**M1 Pacific Motorway extension to Raymond Terrace (SSI 7319)
Advice on the Environmental Impact Statement (EIS)**

Thank you for the request for advice from Public Authority Consultation (PAE-24749572), requesting the review by the NSW Environment Protection Authority (EPA) of the Environmental Impact Statement (EIS) for the proposed M1 Pacific Motorway extension to Raymond Terrace (Application SSI-7319).

ATTACHMENT A: EPA COMMENT ON EIS FOR M1 PACIFIC MOTORWAY EXTENSION TO RAYMOND TERRACE (SSI 7319)

Location: L03 - 51 New England Highway, Tarro

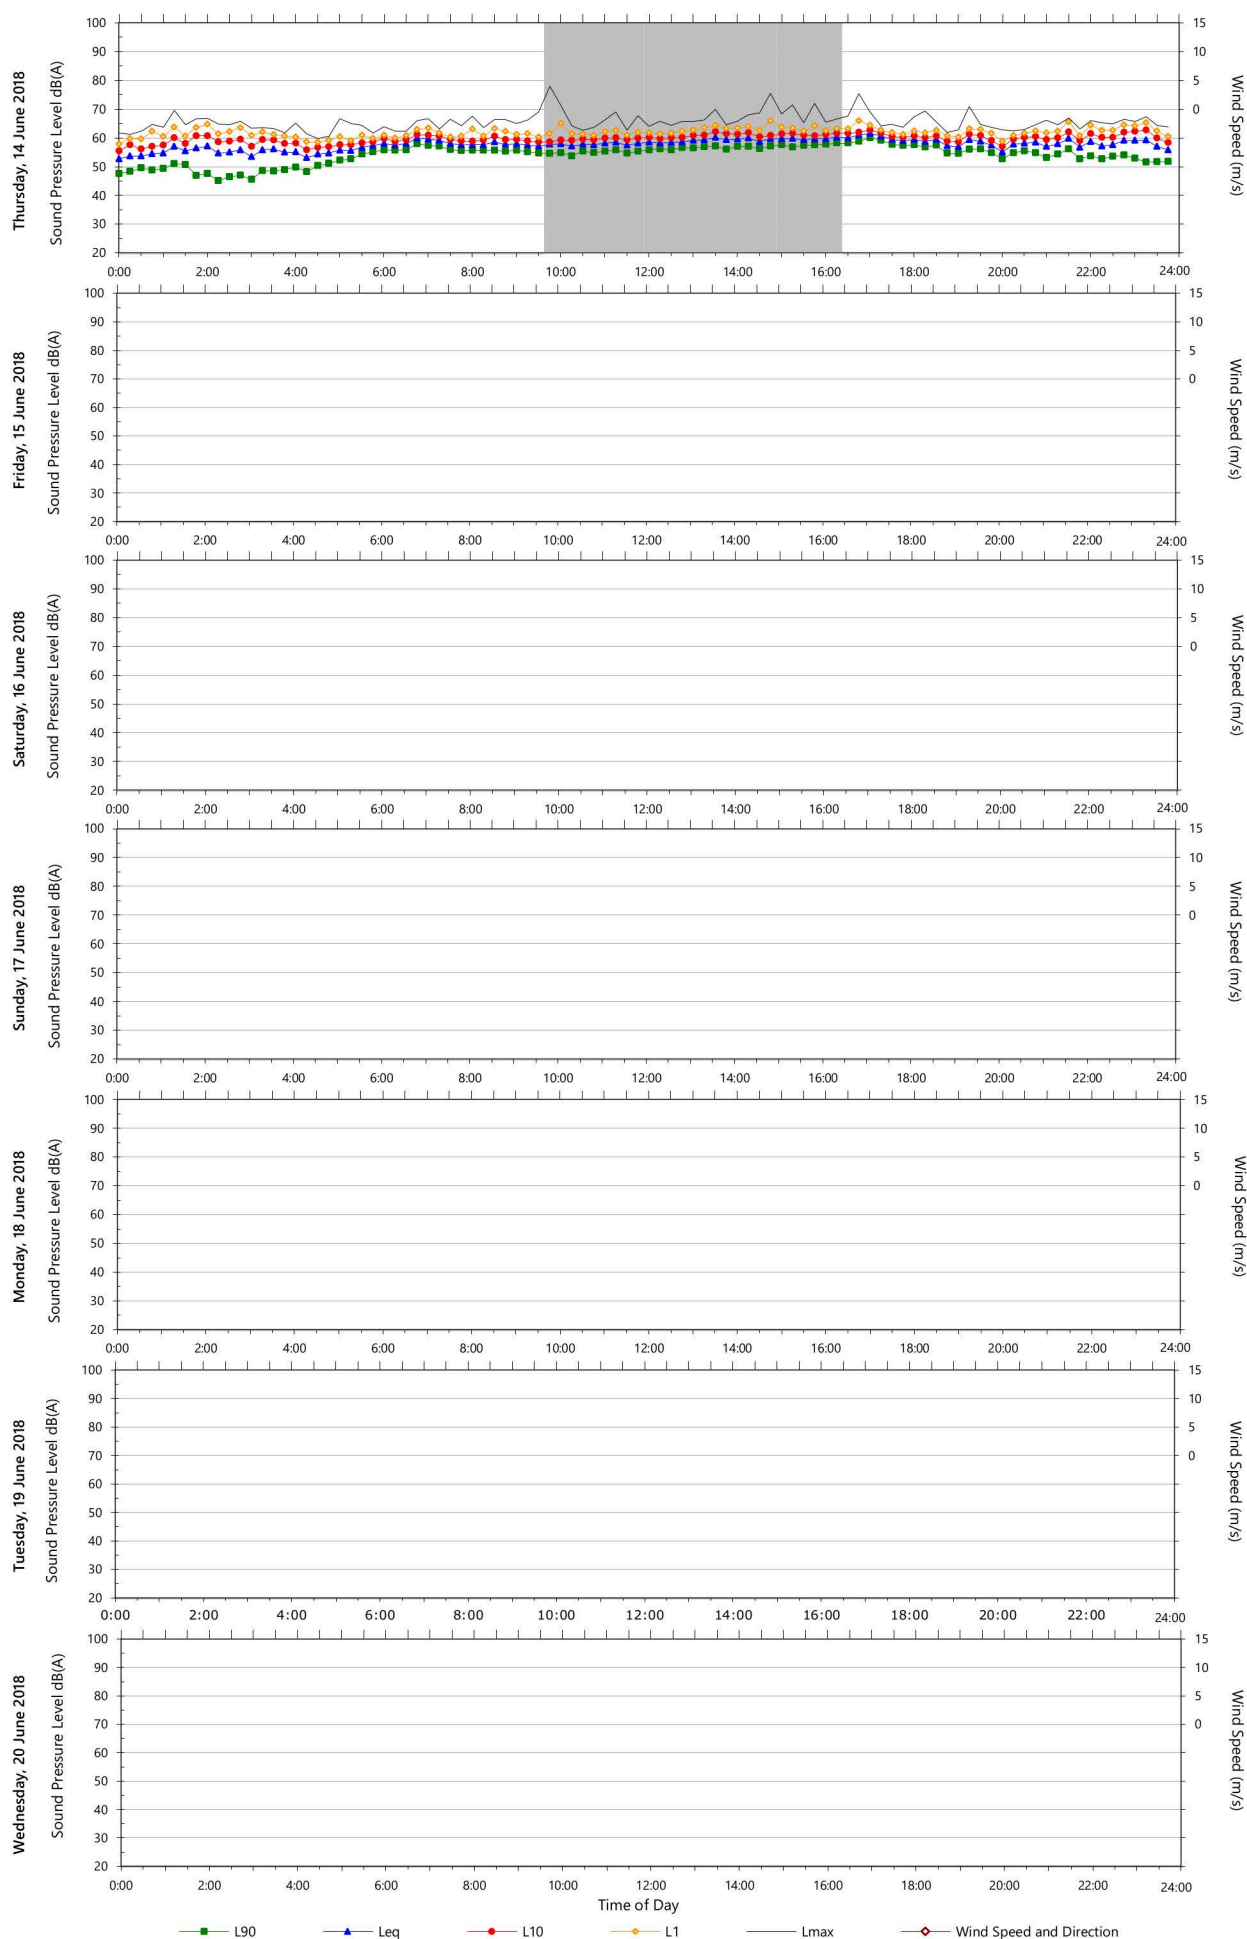
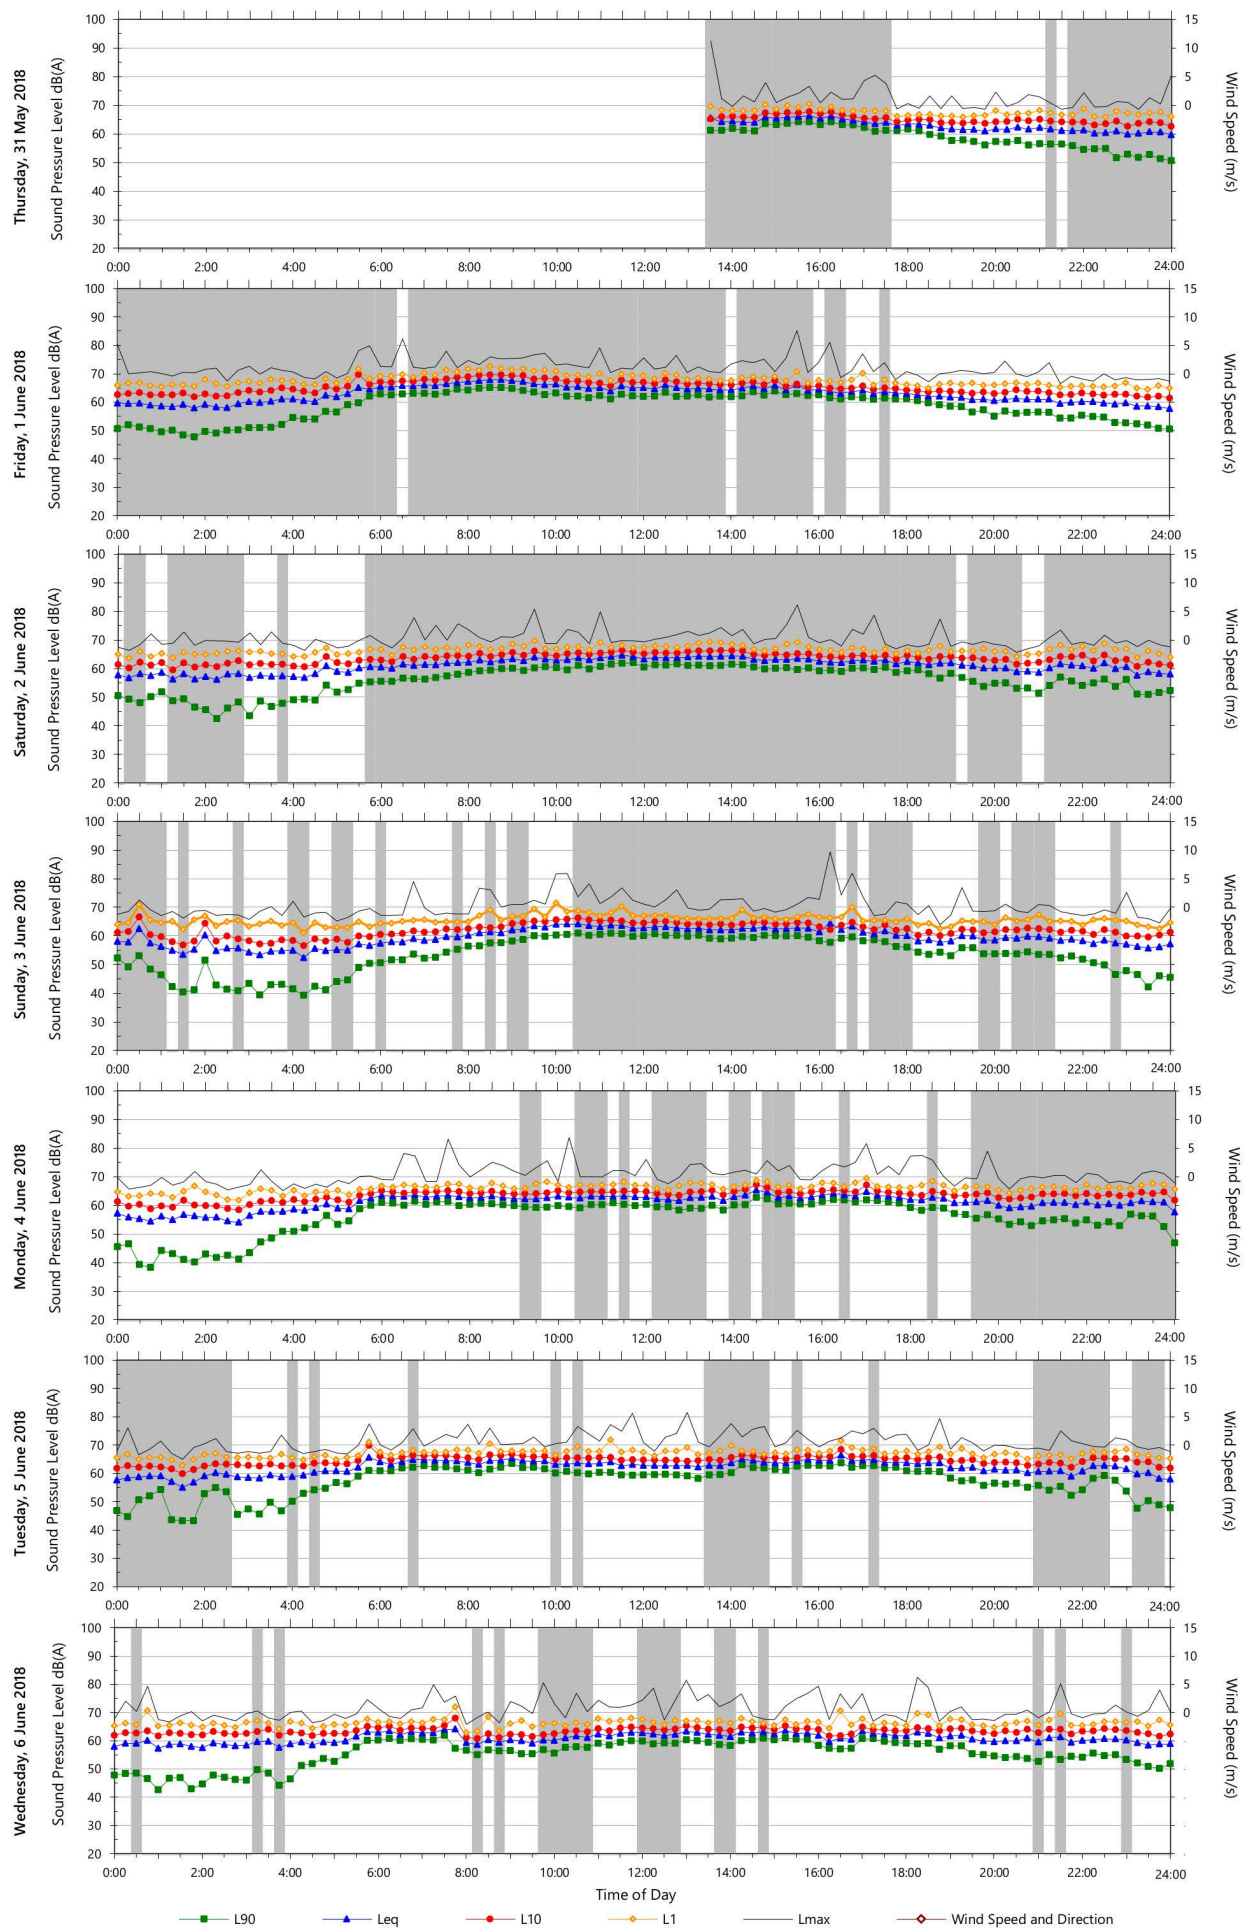
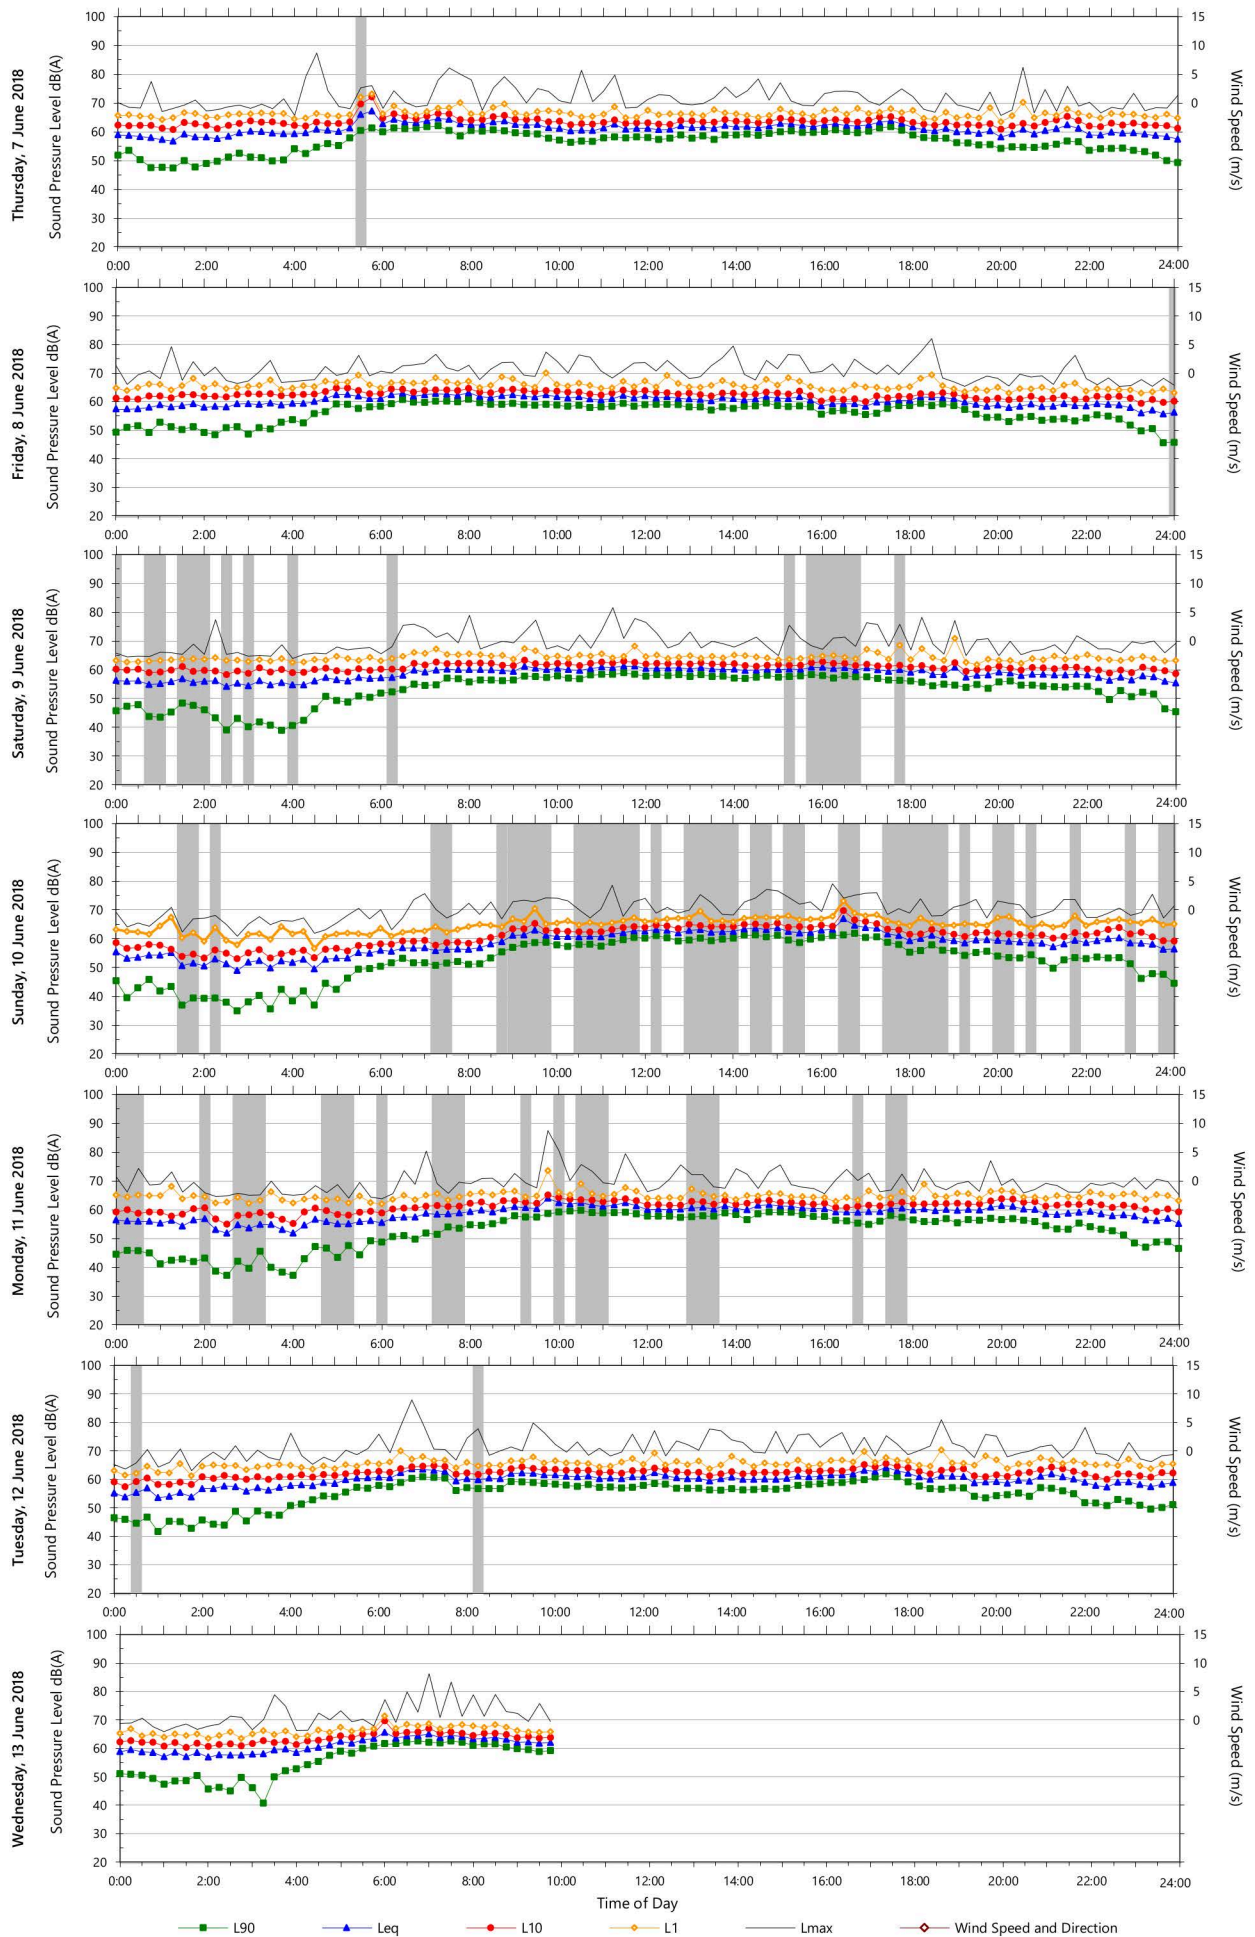
A review of the noise monitoring graphs in NIA Appendix B.2 indicates that further justification for the adequacy of noise monitoring presented or additional information is required.

A significant amount of data appears to have been excluded due to either inclement weather or extraneous noise. The EPA is concerned that the extent of data excluded means that it may not be representative of long term background noise levels, and therefore its suitability to be used to establish reliable noise management levels could be called into question.

Locations L01 to L014 (inclusive) appear to have no more than 5 and in some cases less than 3 valid periods out of the total monitoring duration. Locations L15 to L20 appear to be less affected, however there it is still not clear if sufficient valid data has been presented.

Fact Sheets A and B in the Noise Policy for Industry (NPfI) set out the EPA's requirements for establishing background noise levels. Due to the amount of data excluded, it is currently not clear if these requirements have been satisfied nor if sufficient valid data has been presented in order to establish representative background noise levels.

Noise monitoring was also conducted in 2016 for the purposes of measuring road traffic noise. Due to the amount of data excluded at Locations L13 to L20, further justification is needed that the remaining data, after invalid samples were excluded, provides sufficient amount of data to enable a representative calculation of the traffic noise descriptors.

The proponent reviews the noise monitoring data in the NIA in the context of the monitoring requirements set out in the NPfI and for each location and either:

- Provide a justification and demonstrate that the requirements of the NPfl have been fulfilled; or
- Provide additional data that fulfills the monitoring requirements in the NPfl.

The EPA also recommends that the proponent either:

- Provides justification and demonstrate that the data presented for road traffic noise descriptors is sufficient to be representative; or
- Provides additional valid data.
